OBJECTION: MIXED-USE DEVELOPMENT MACKENZIE ST, LAVENDER BAY SSD-88702457

I am the owner and resident of 12 Wilona Avenue, Lavender Bay. My home is an early 1900s single storey terrace and is identified as a contributory item within the Lavender Bay Heritage Conservation Area, it is directly across the road from the development site and is one of the properties most immediately affected by the proposed development.

NORTHERN ELEVATION - NO. 2 - 14 WILONA AVENUE

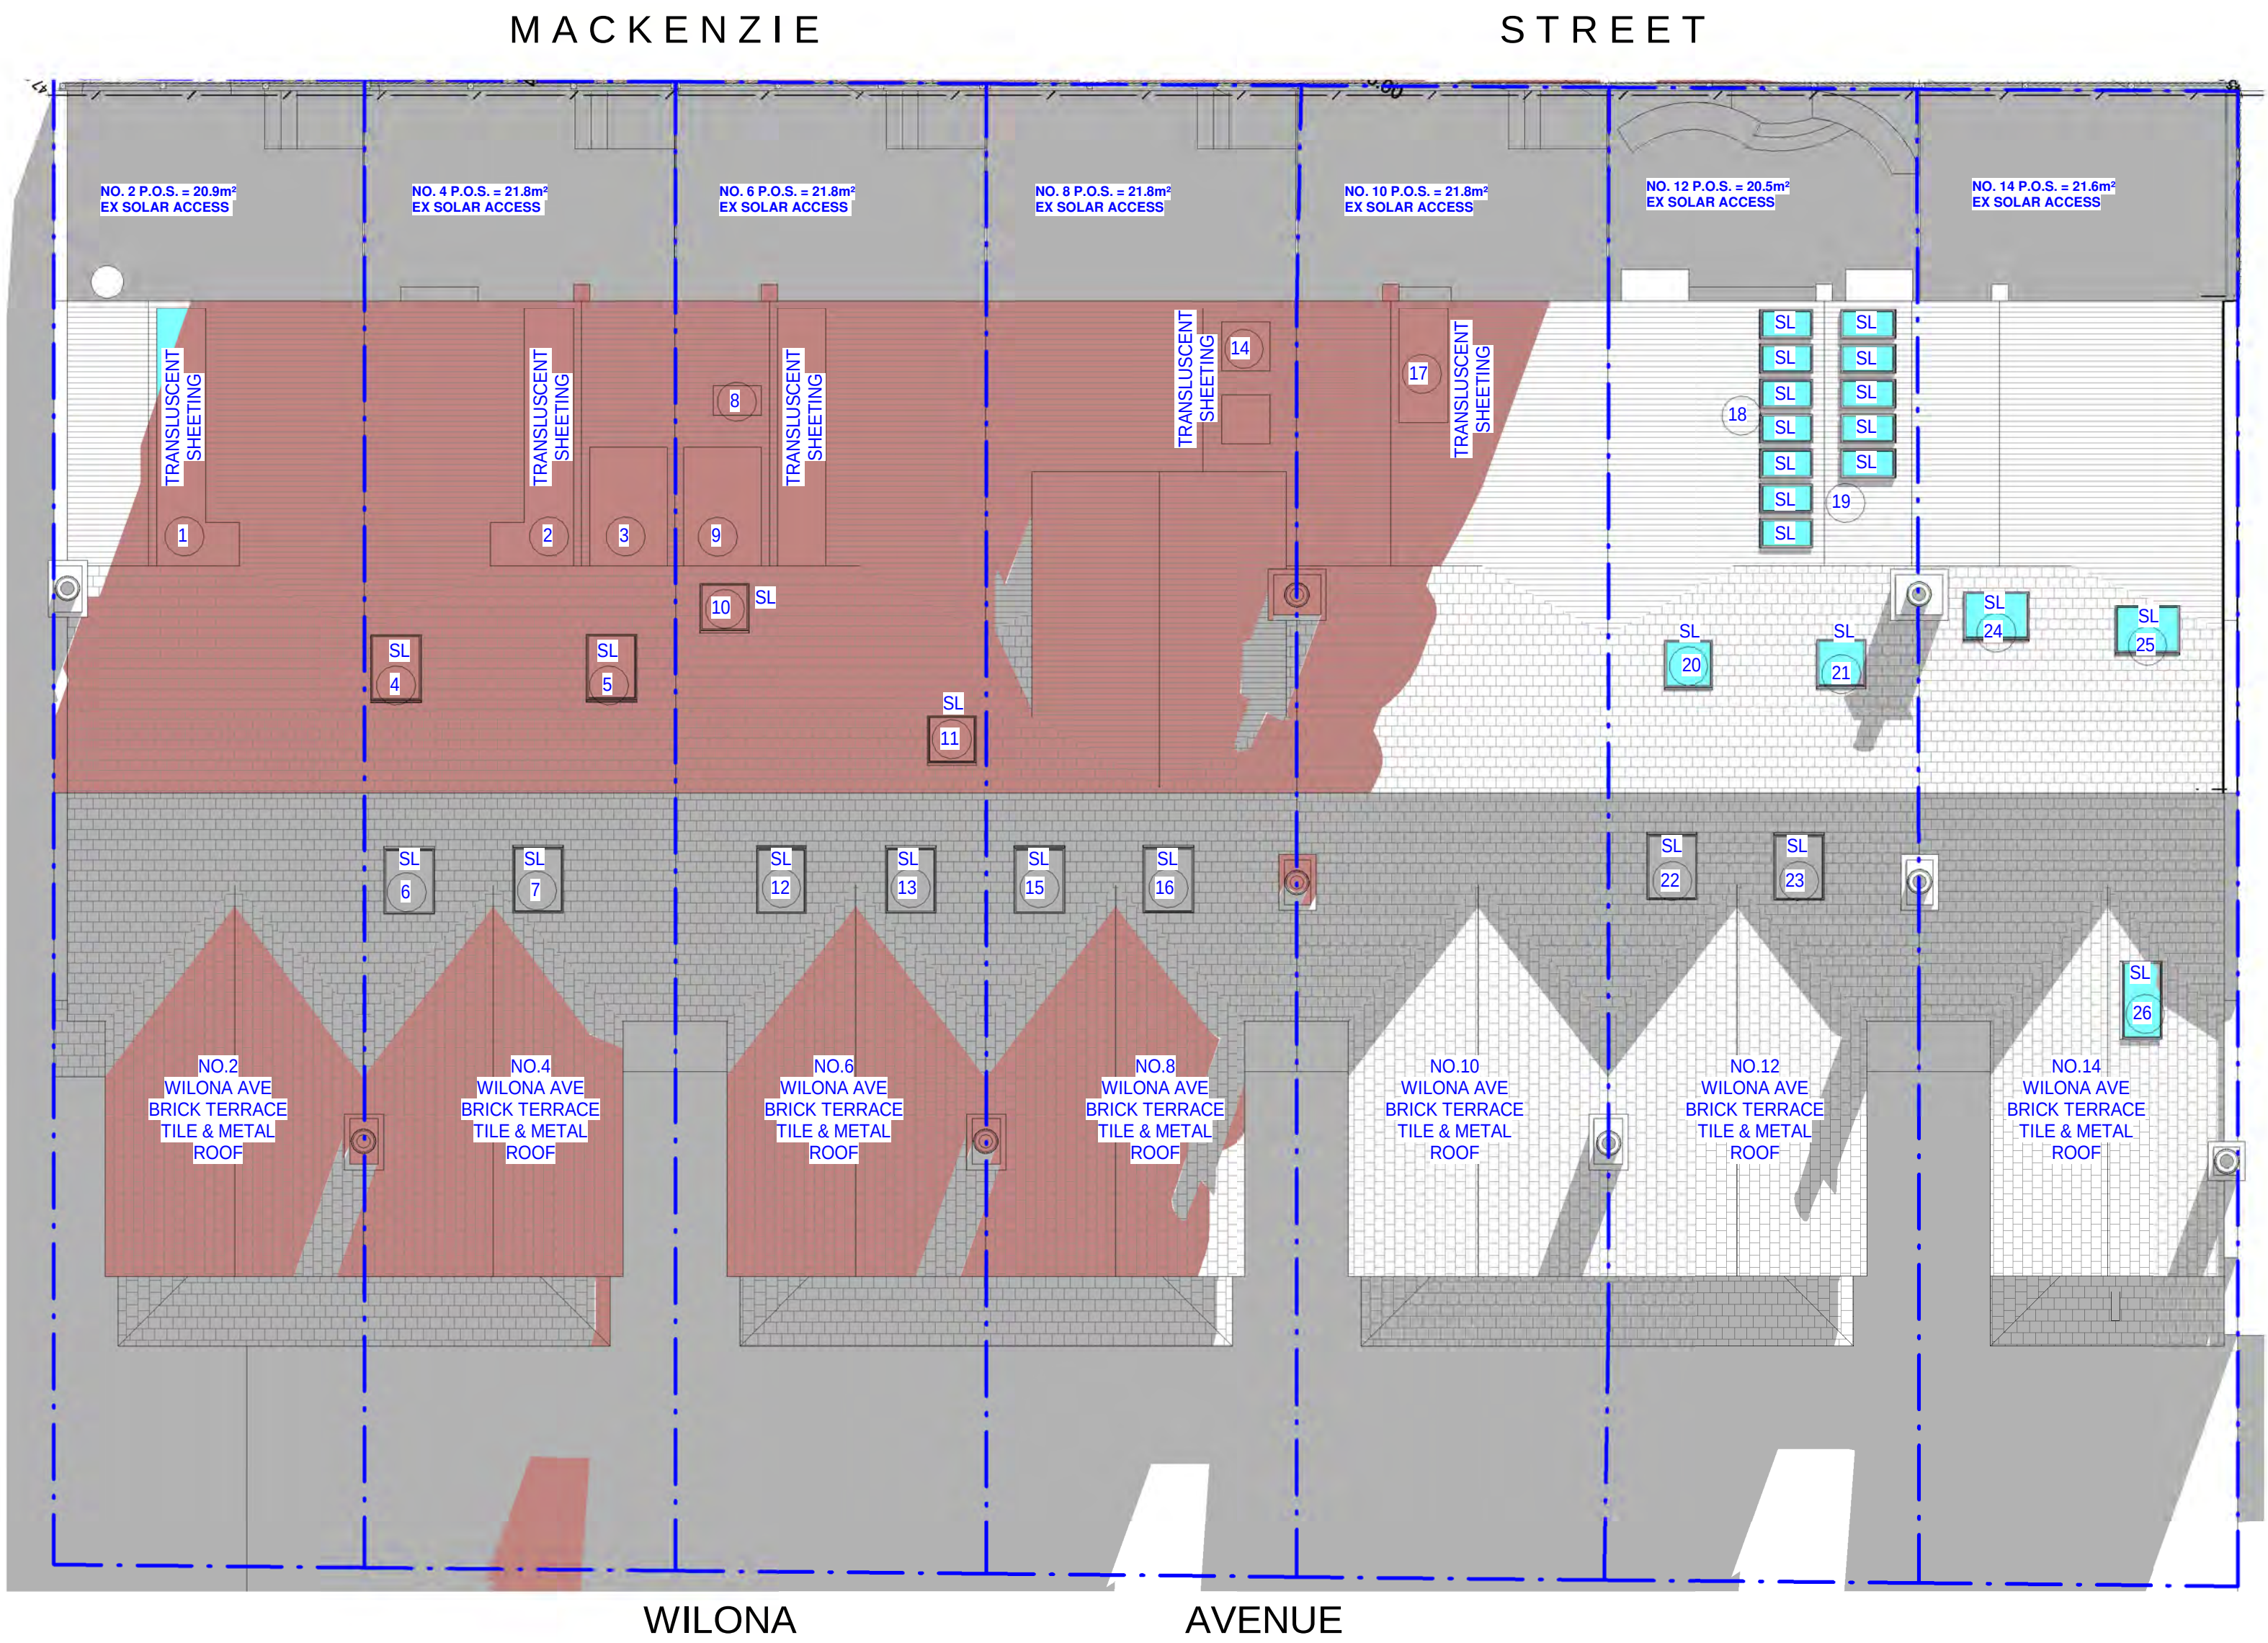
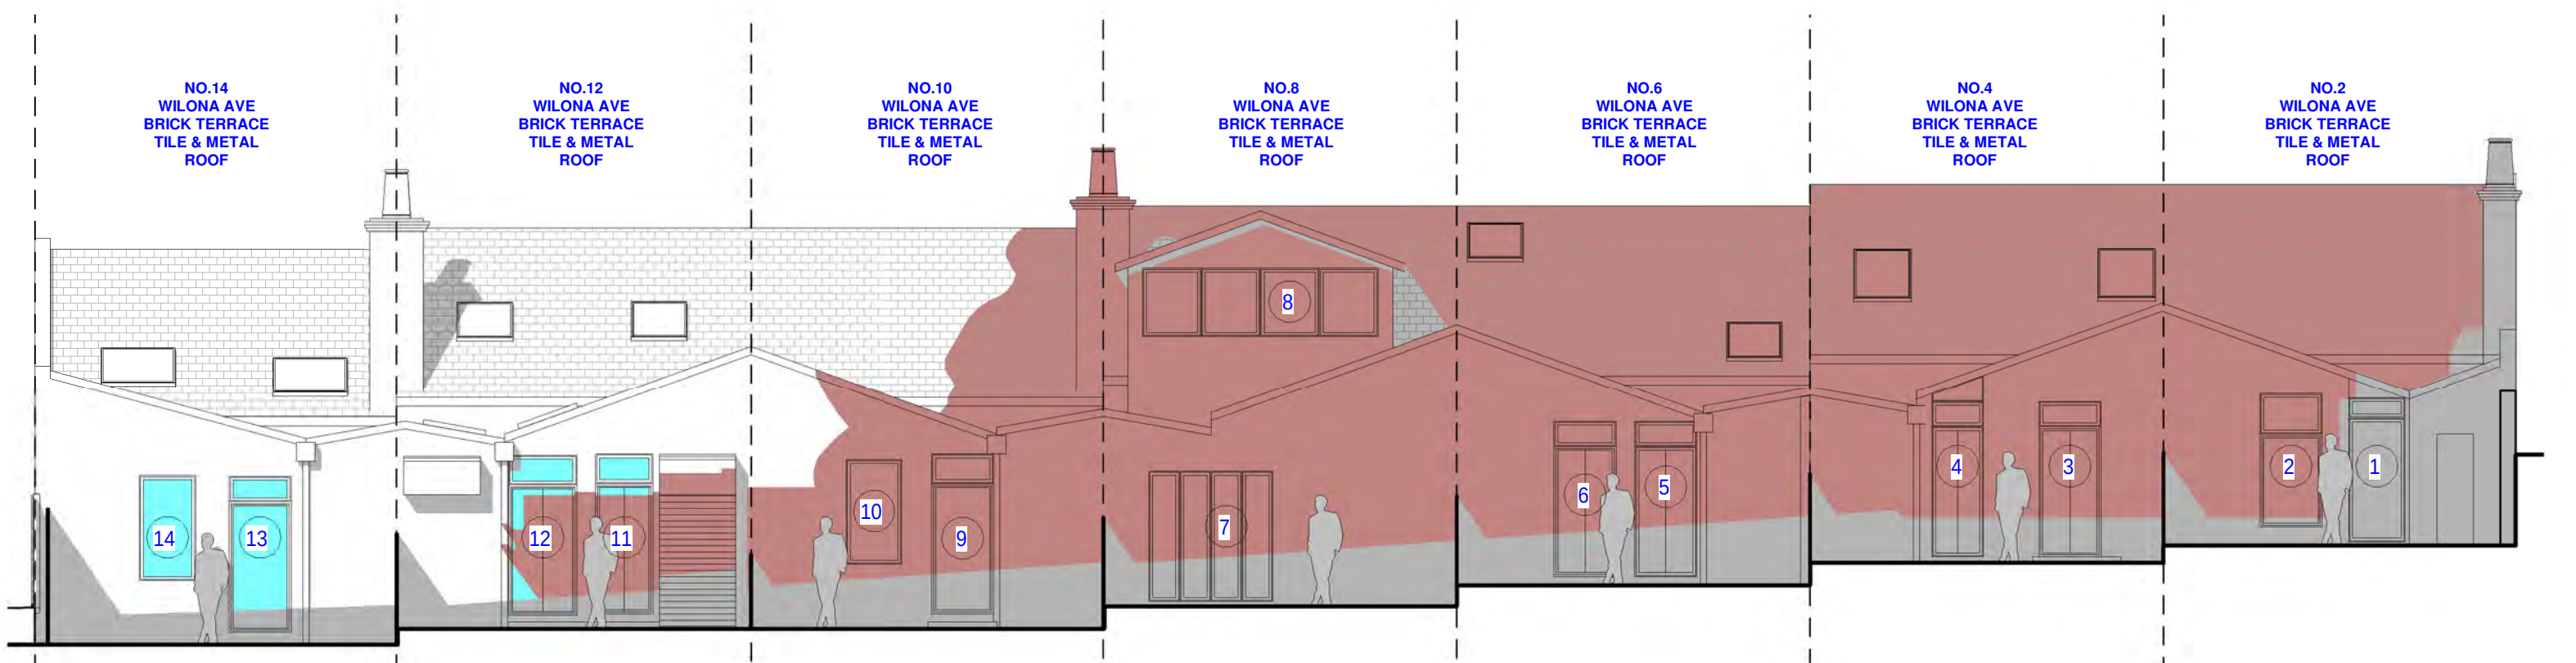
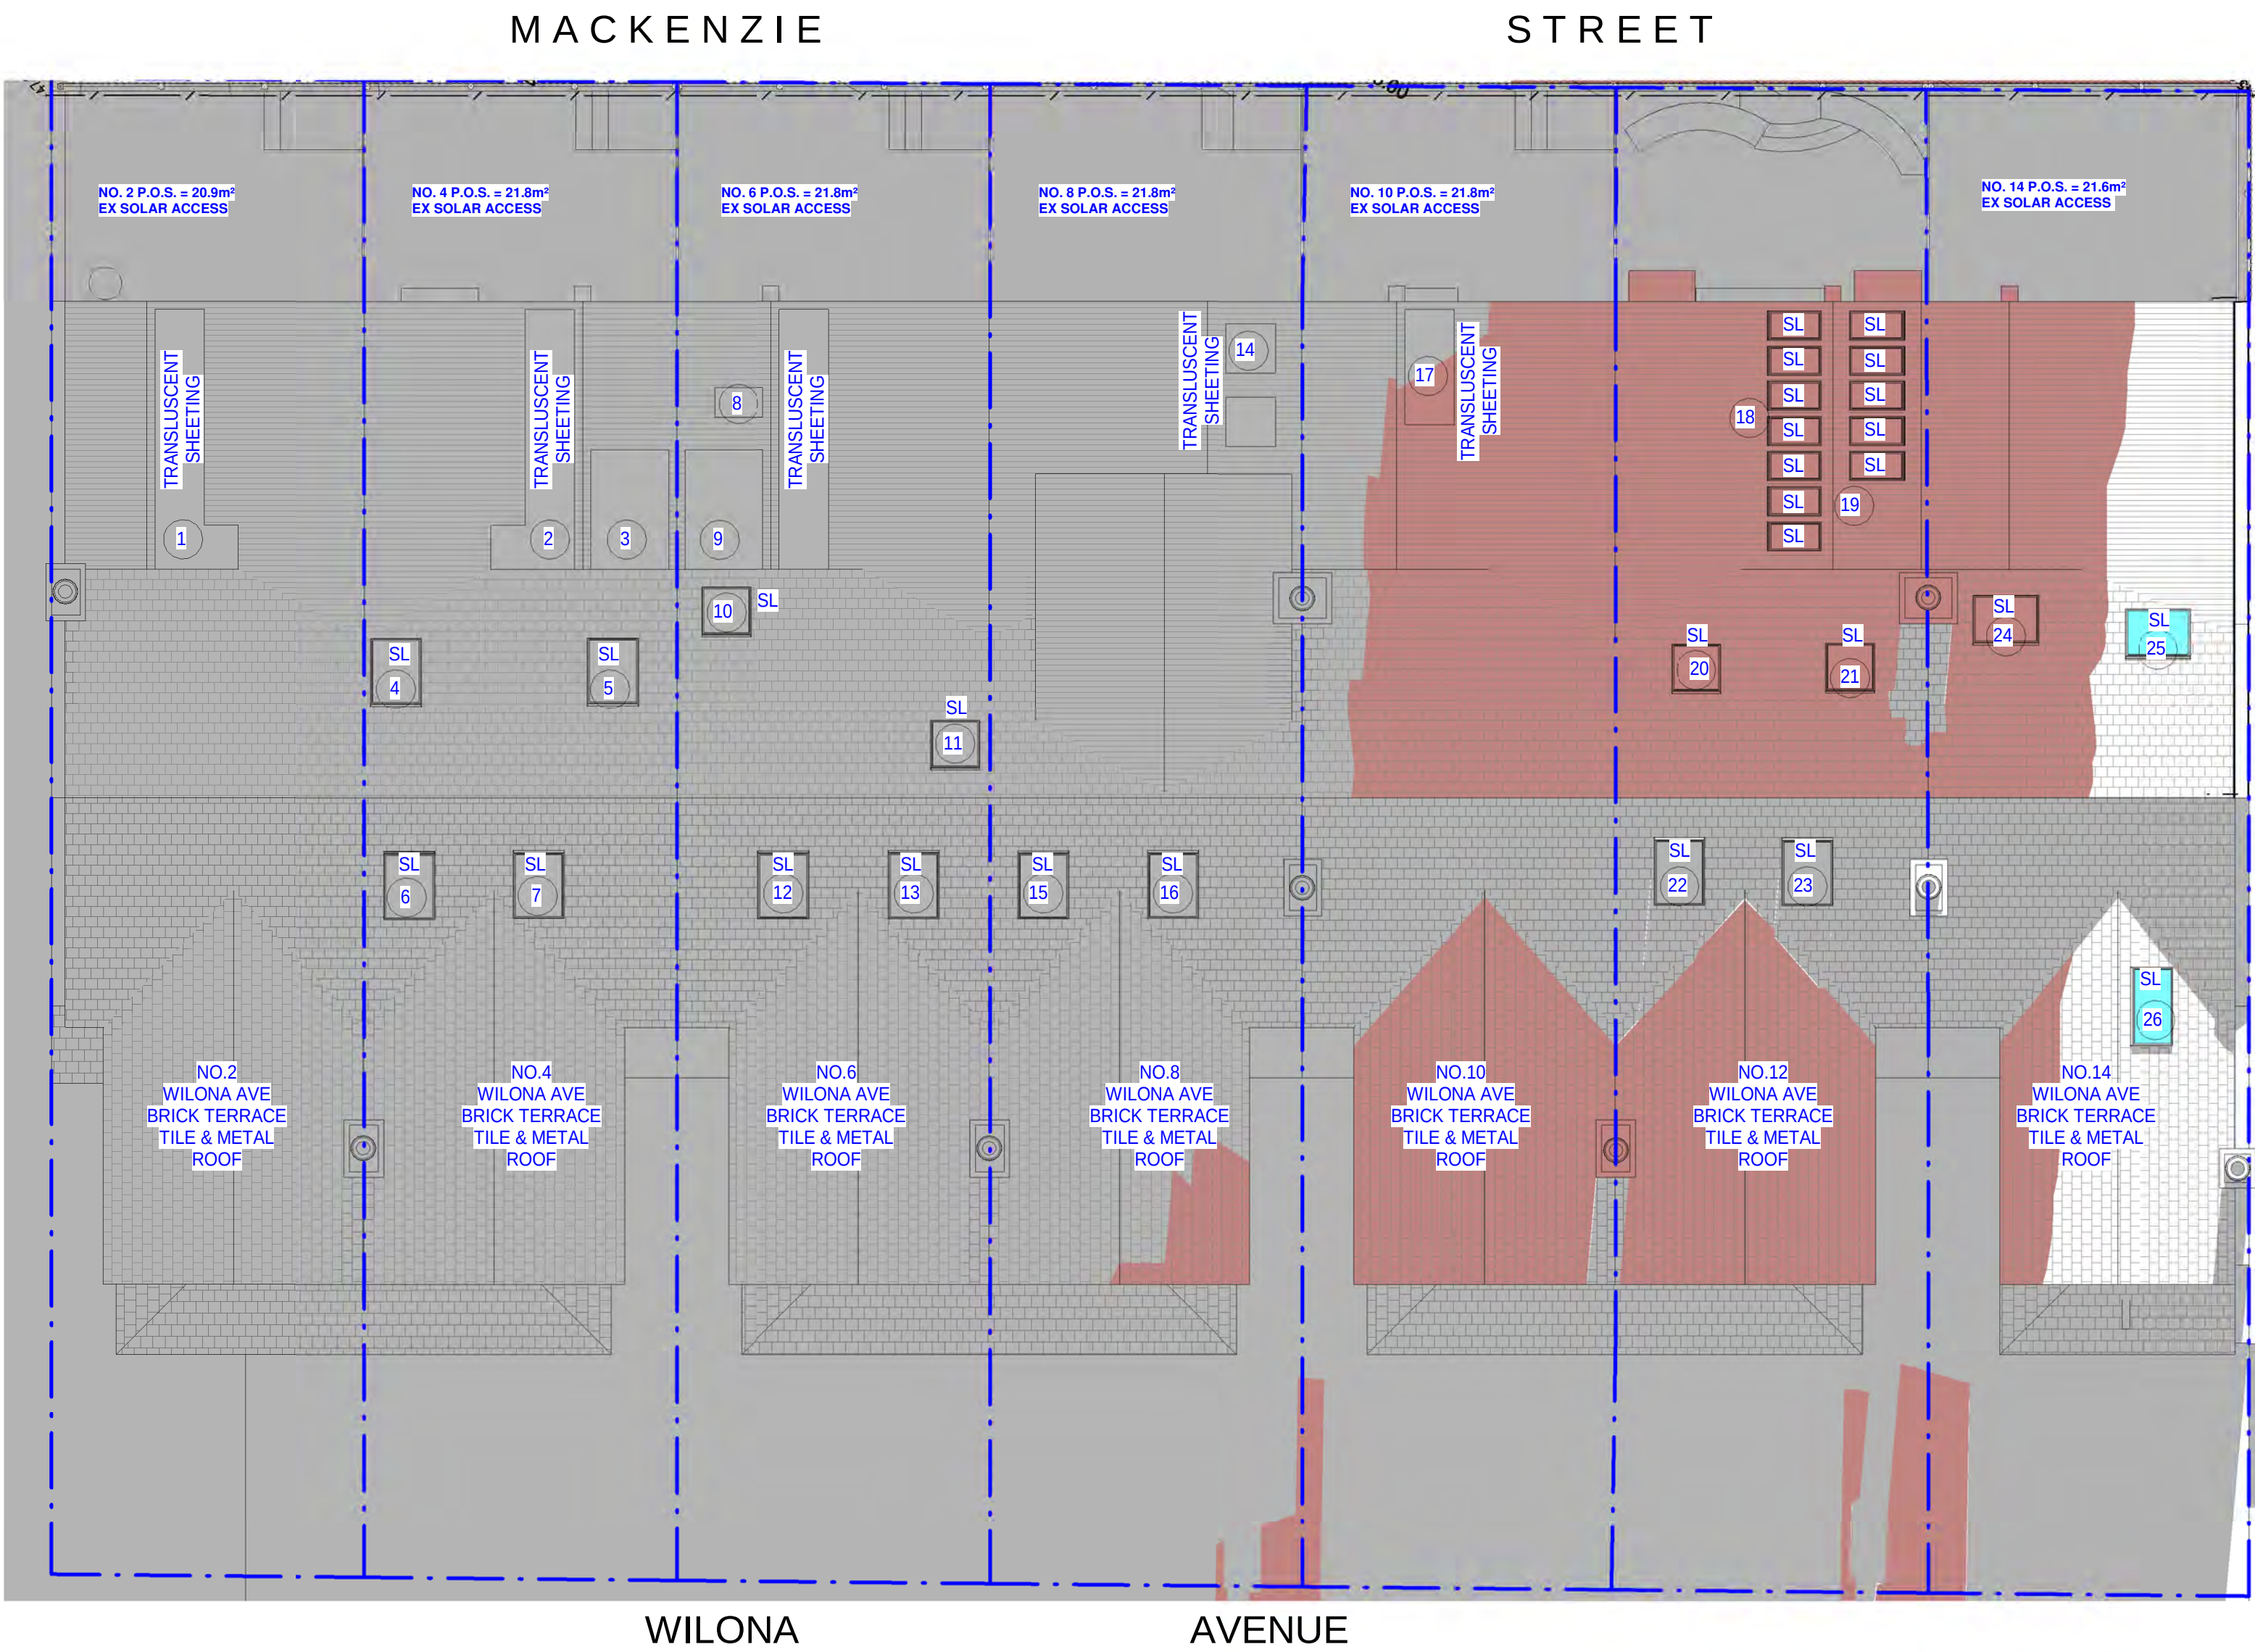
The loss of solar access to my home is another one of my strongest objections to this proposal. I live directly opposite the development and the independent solar analysis commissioned shows that the impact on 12 Wilona Avenue will be severe.

This is not a minor reduction at the margins. The proposed development will remove between 50% and 67% of the existing winter solar access to the windows serving my principal living areas. My main living area currently receives approximately 3 hours of solar access on 21 June and would be reduced to 1.5 hours. My kitchen currently receives approximately 6 hours and would be reduced to only 2 hours. These two spaces are used most frequently in our home, they are both our main living areas perhaps because they are the two areas with solar access. Being a single storey terrace house solar access is limited to the centre and southern side of the house our main living area naturally exist in the northern side of the house and we spend the majority of our time there.

The effect on the skylights that provide natural light to my home is even more serious. Of the six skylights/roof areas assessed at No. 12, five lose between 60% and 100% of their existing winter solar access. Two lose all of it, reducing from one hour of direct sunlight to zero. The remaining skylight still loses 50%.

The elevations show people standing within the courtyards and allow the shadow to be assessed at human height, not just at ground level. The northern elevation specifically includes No. 12 Wilona

Avenue and shows the relationship between the additional development shadow and the areas actually occupied by residents.
